PLANNING APPLICATION REPORT

REF NO: P/61/09/

LOCATION: 91 West Front Road
Pagham

PROPOSAL: Demolition of garage, single storey extension including garage. Resubmission following P/18/09.

PROPOSED LAYOUT

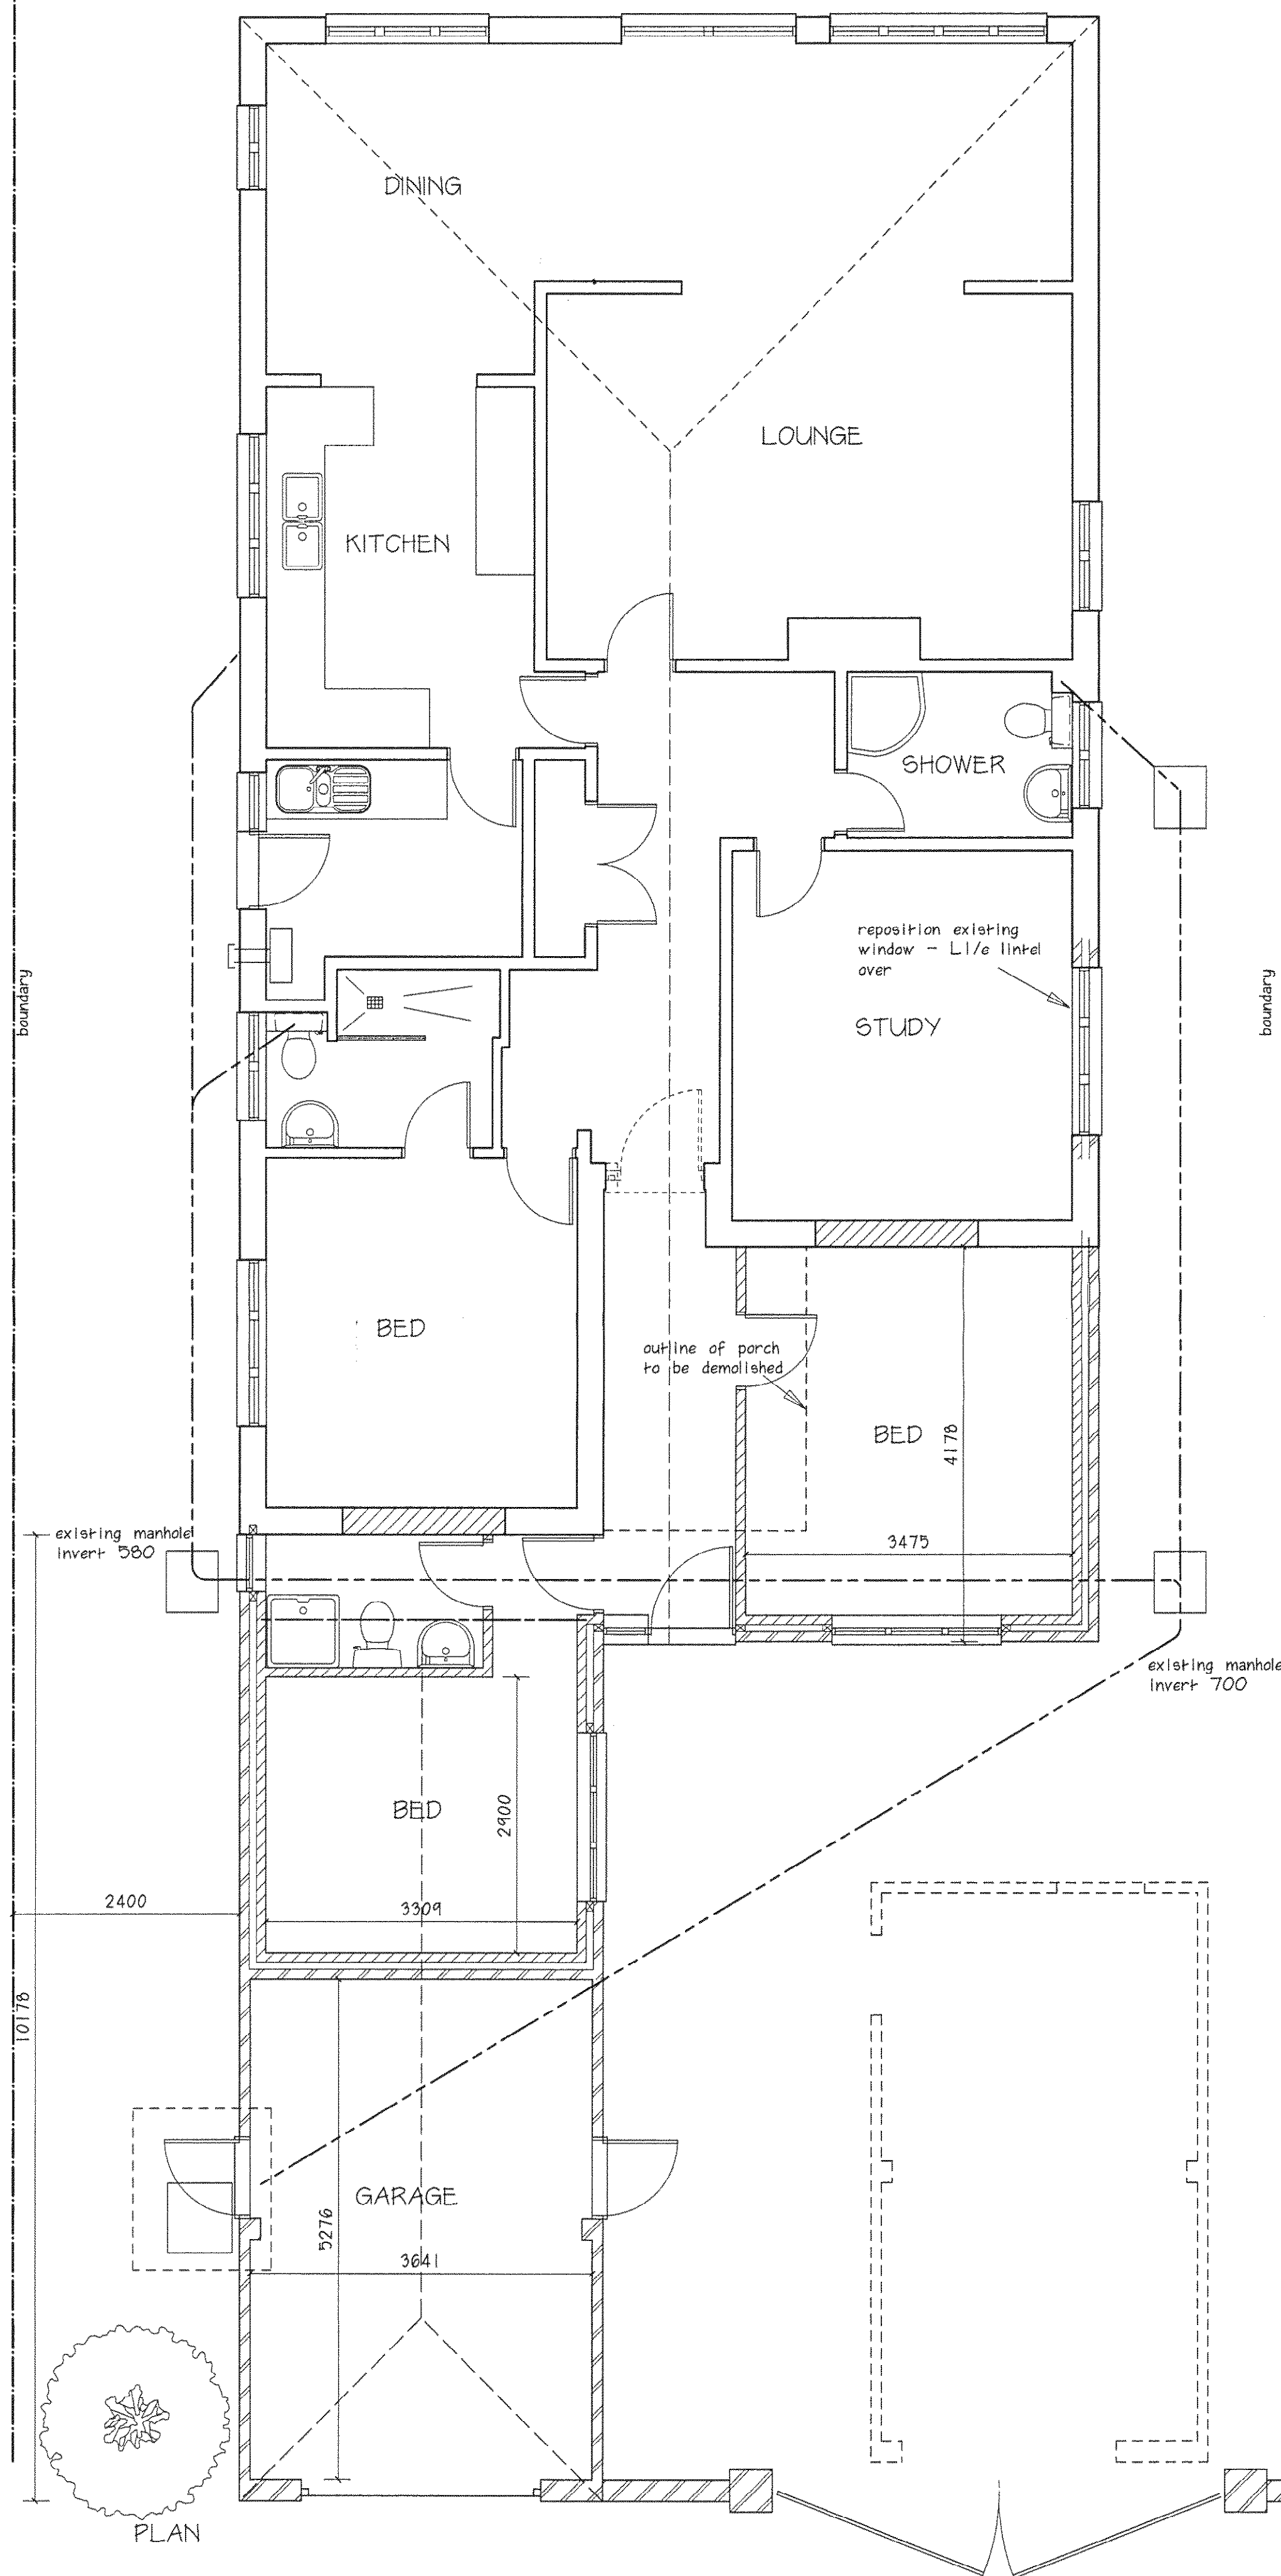
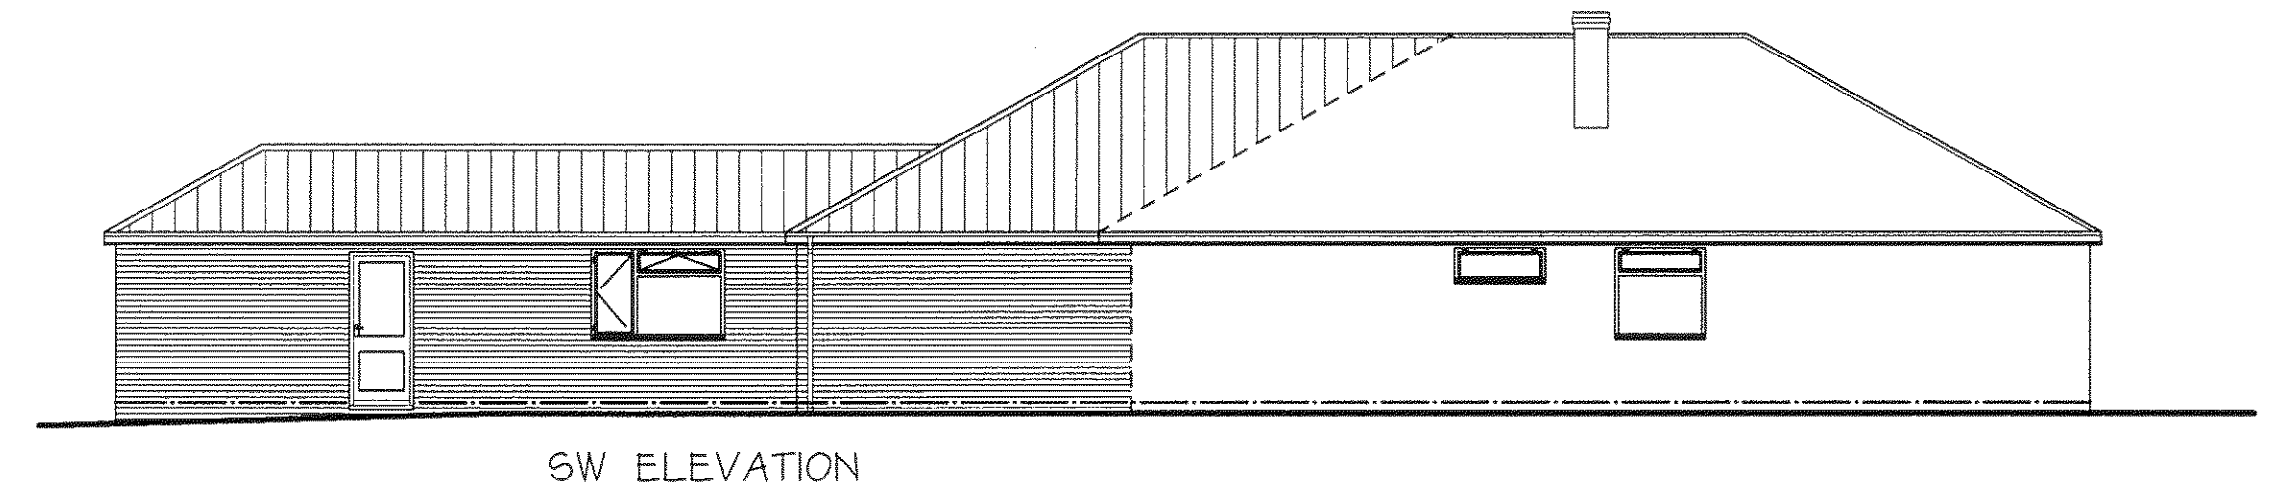
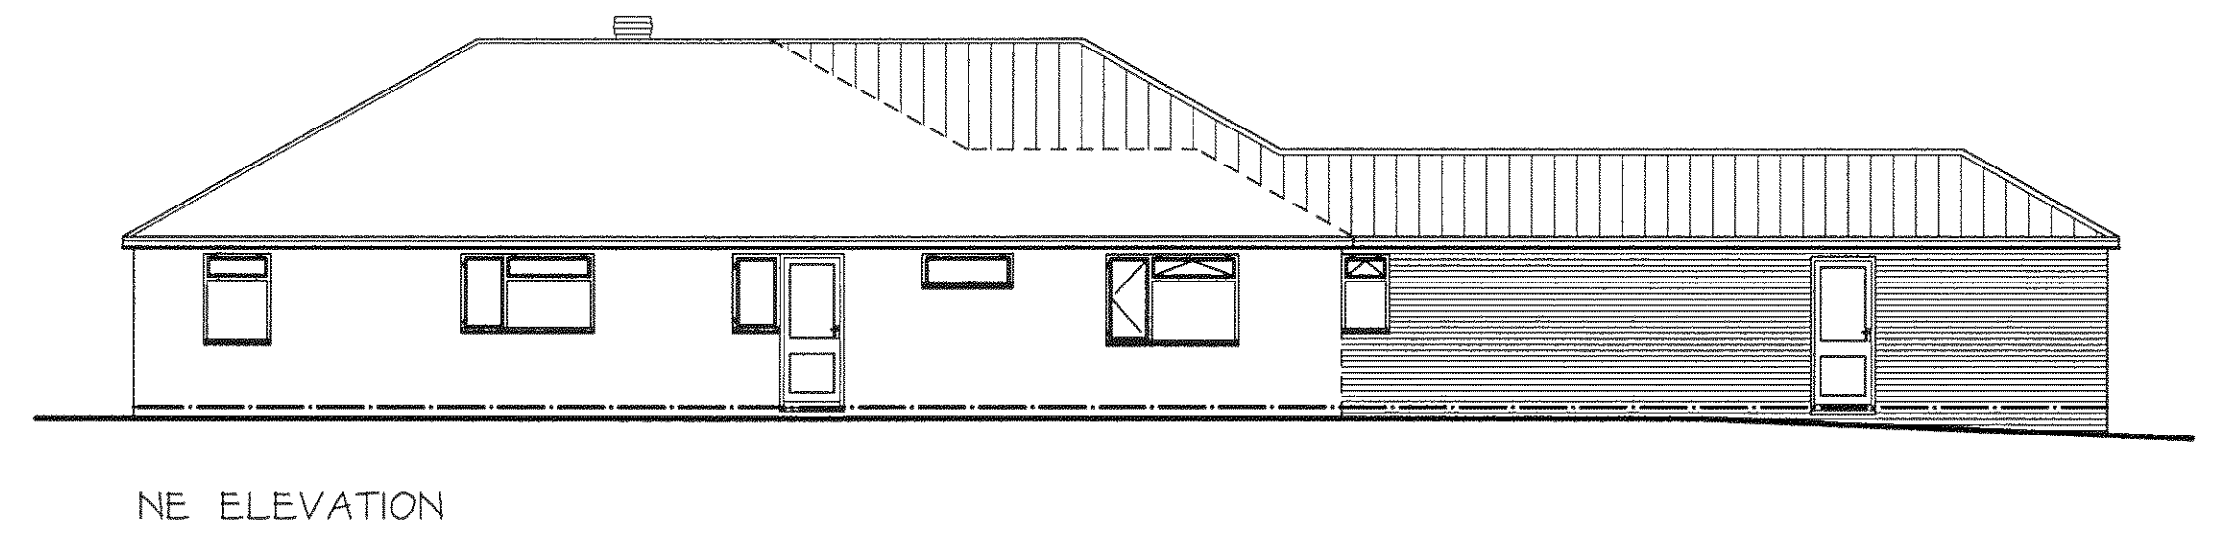
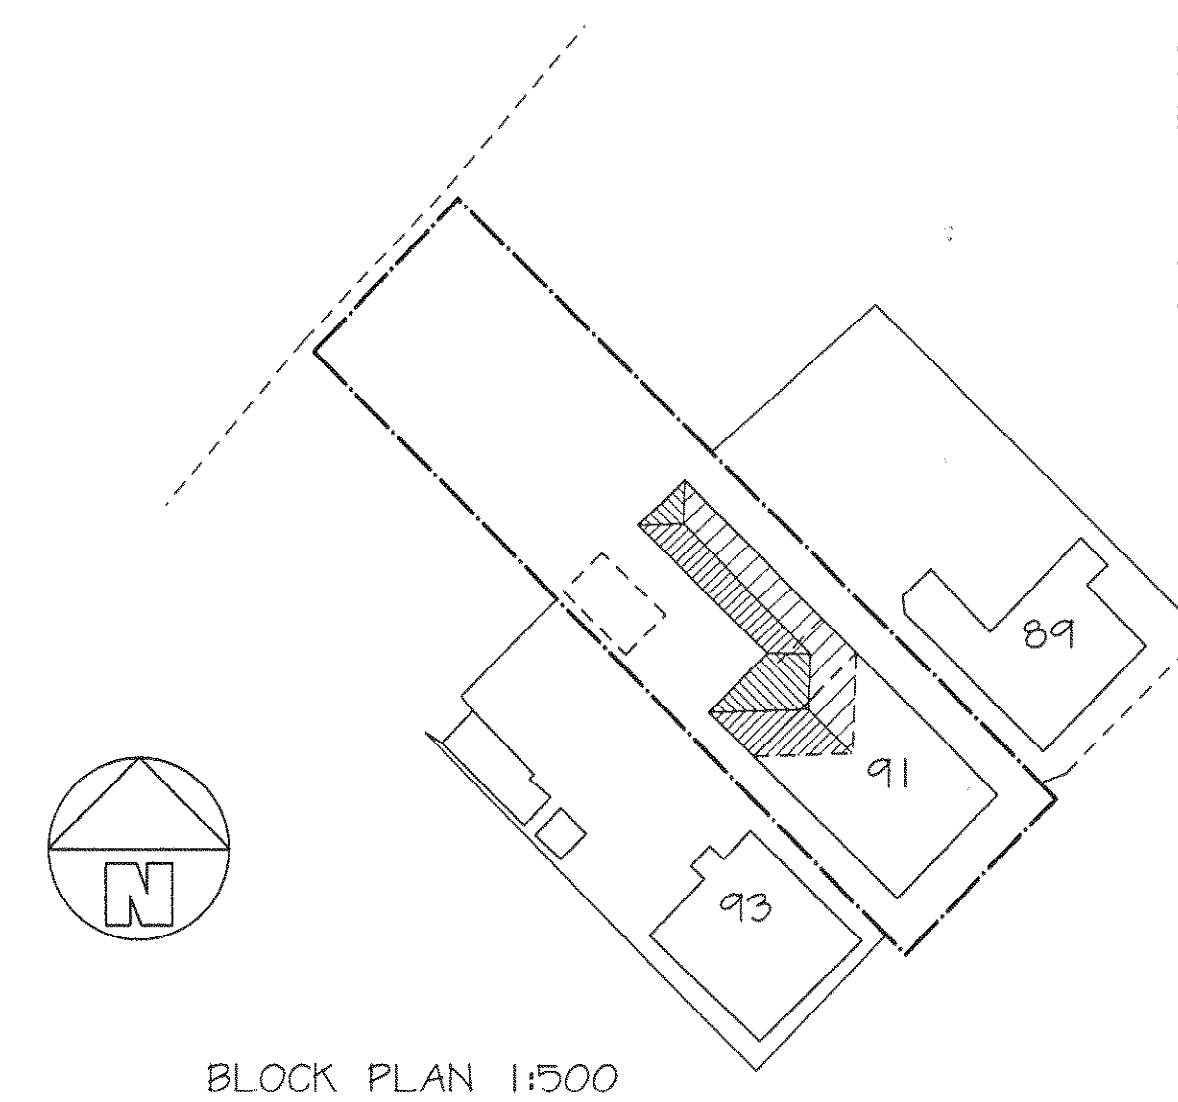
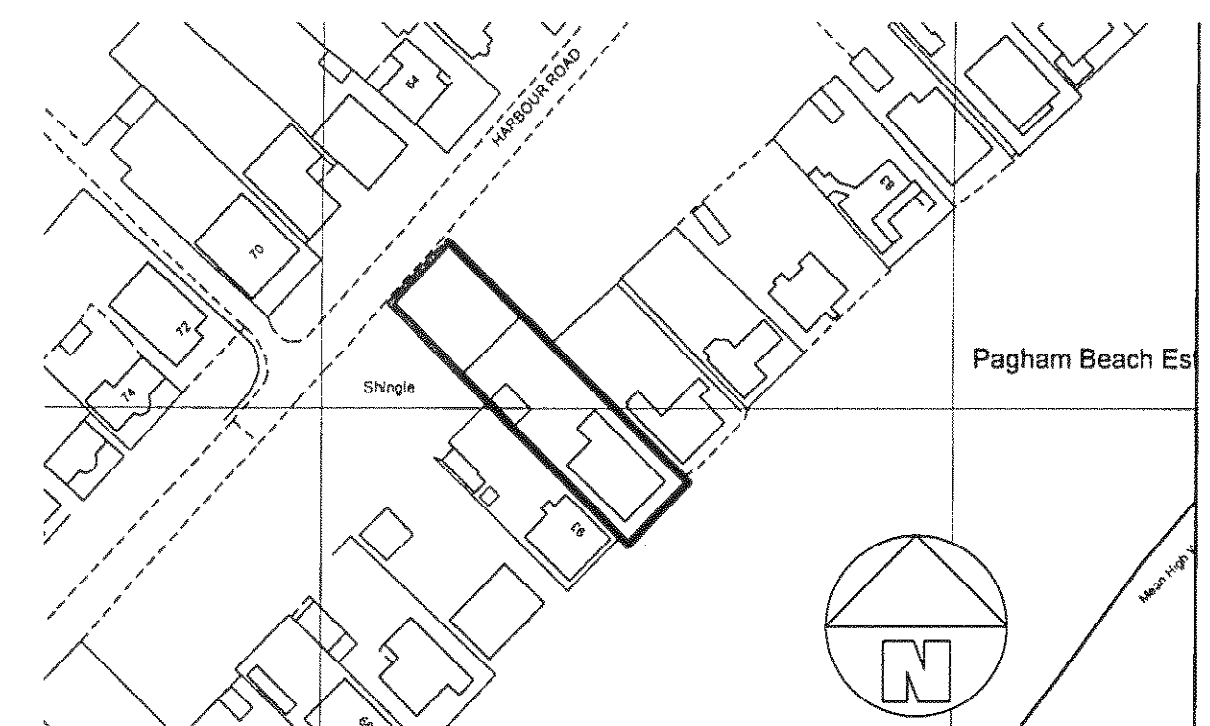
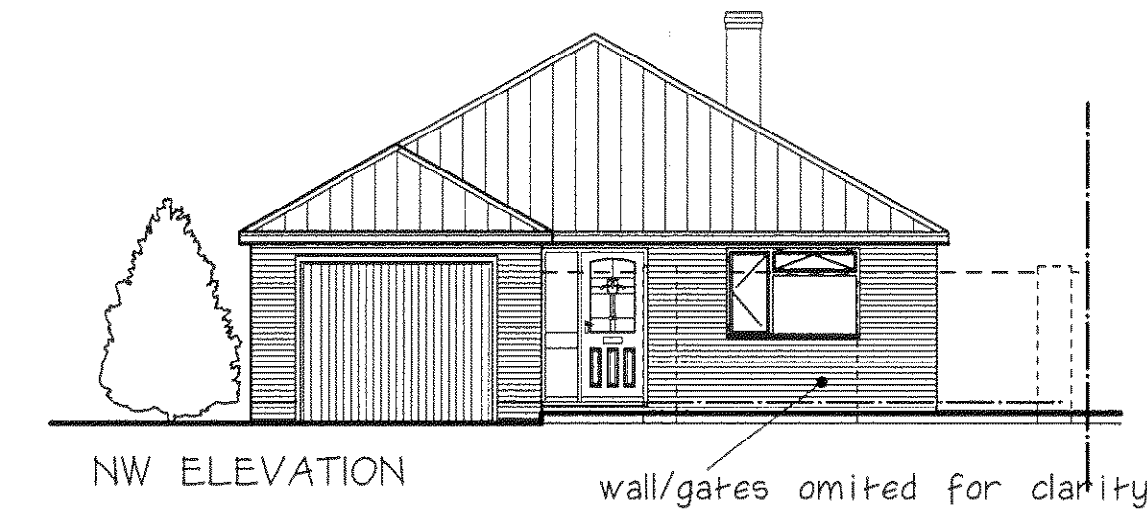
This application seeks to construct a single storey 'L shaped' extension to the front of 91 West Front Road, Pagham. The proposed extension would measure approximately 9.3m in width, 13.1m in length, and 5.1m in height. The development would also involve the demolition of an existing detached garage located on the western side of the site.

At present the most forward flank of the property is located some 37m away from Harbour Road, the highway which provides vehicular access to the site. The proposal would see the construction of an extension which would extend from the eastern side of the front of the property by some 13m.

The addition of an extension of such length would result in a significant encroachment towards the front boundary of the site, and as such is deemed to represent an obtrusive addition to the street scene. The scale, projection and a-symmetric nature of the proposed extension is also such that it is considered to be out of keeping with, and therefore detrimental to, the character and appearance of the existing dwelling.

- 1 The extension by reason of its siting, size and design would detract from the symmetrical appearance of the bungalow and would be out of character and detrimental to the visual amenities of the area which is defined as an Area of Special Character. The development would therefore be contrary to policies GEN7 and AREA1 of the Arun District Local Plan.

BLOCK PLAN 1:500

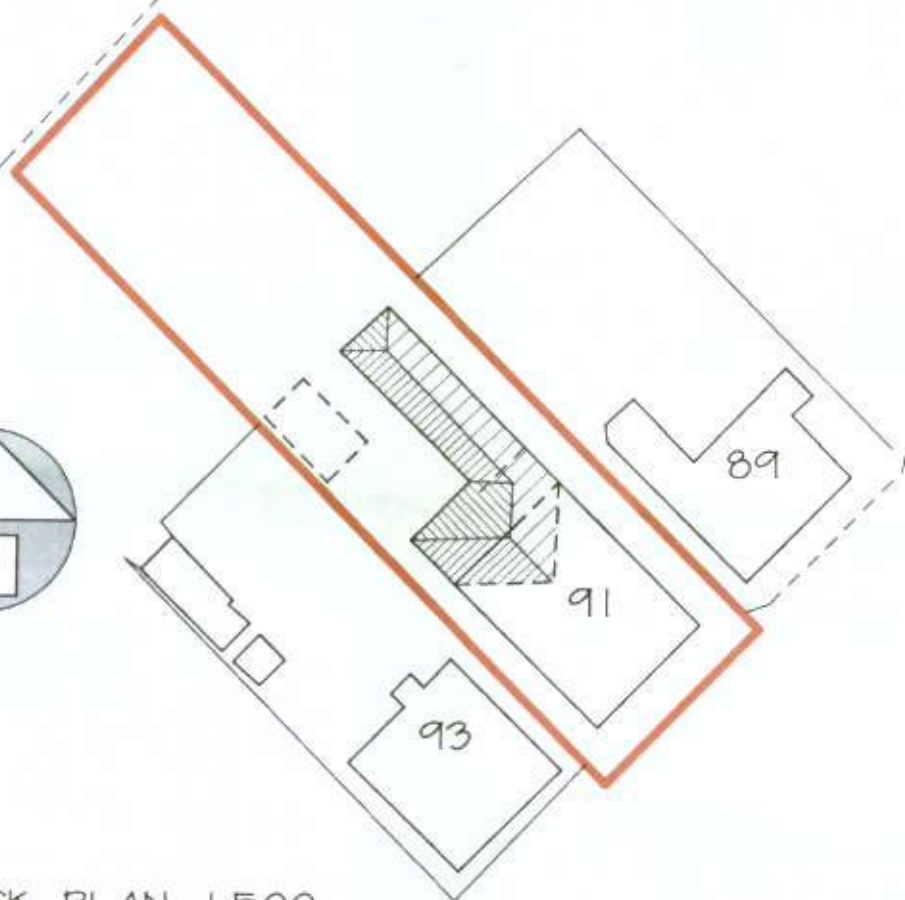
It has also been noted that the application indicates that the current open area to the front of the site is to become part of the residential curtilage. The open grassed area between the dwelling and the southern side of Harbour Road is part of a substantial area of open space, and is

considered to contribute to the spacious feel that characterises the locality. It is considered that the enclosure of such a space would also cause detriment to the visual amenities of the locality. Indeed, part of the Development criteria of the Pagham Village Design Statement states that development in existing Open Spaces should be excluded as far as possible.

- 2 The proposed extension of the residential curtilage would result in a loss of open space, which contributes significantly to the character and appearance of the locality. The proposal would therefore be detrimental to the visual amenities of the locality and the Area of Special Character, contrary to policies GEN7 and AREA1 of the Arun District Local Plan.
